**Clematis Cottage, Main Street, Sibford Ferris,
OX15 5RG**

21/03259/F

Proposal: Alterations and erection of single storey rear extension to replace existing conservatory

Drawing Title:
Proposed Elevations

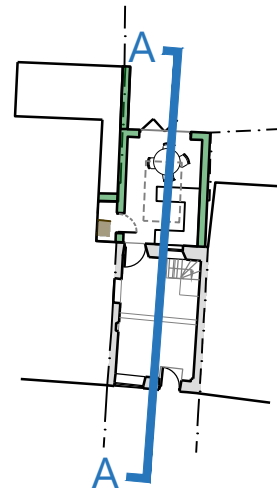
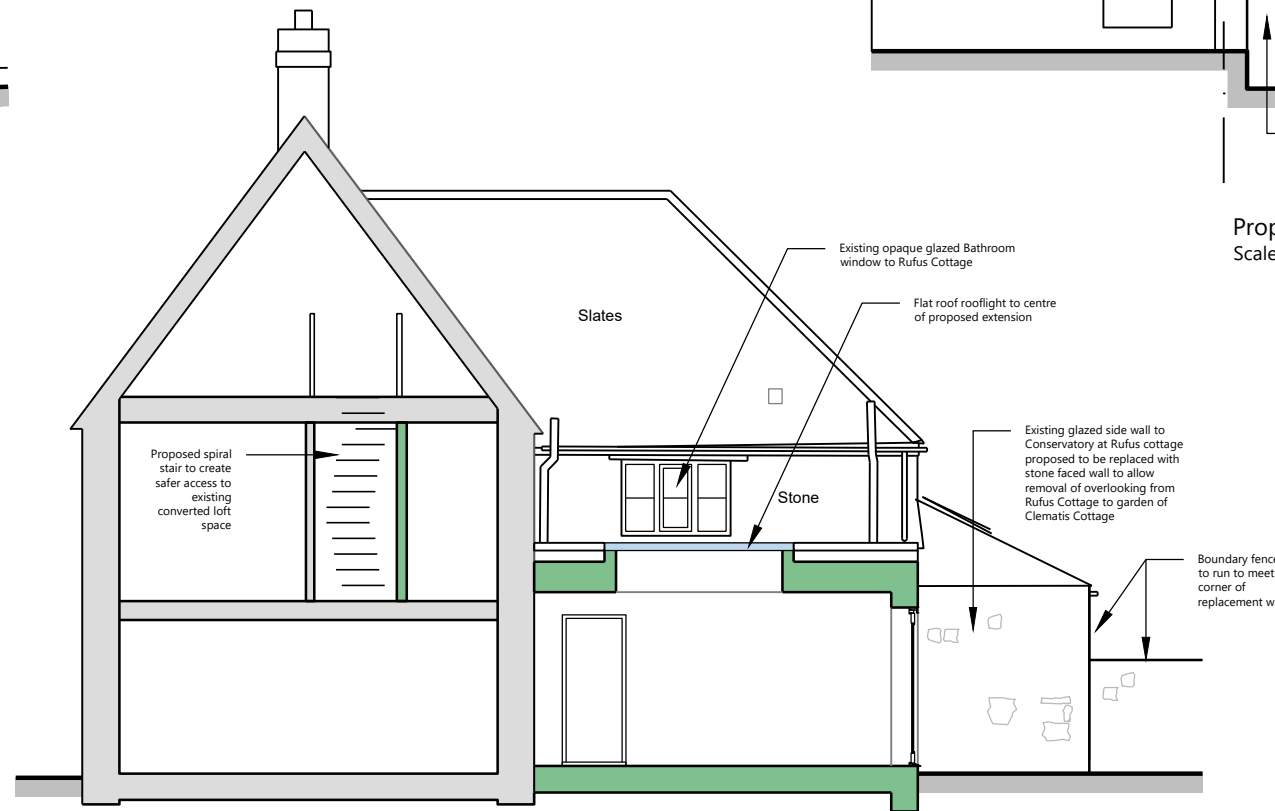
- The proposed use of render to the external walls of the extension is considered to be unfortunate considering the widespread use of natural ironstone across the application dwelling and neighbouring properties. Amended plans were sought and received which detailed stone to match on the rear elevation and this was considered to be an improvement to the scheme and its impact on the character of the dwelling and locality.

- It is noted that render is also visible to the rear of neighbouring properties and as such the render to the side elevations would retain the character of the locality would be retained and so on balance it is considered to be acceptable in this instance.

3. The natural stone to be used on the walls of the rear elevation of the extension shall be of the same type, texture, colour and appearance as the stone on the existing building and shall be laid dressed, coursed and pointed to match that of the existing building.
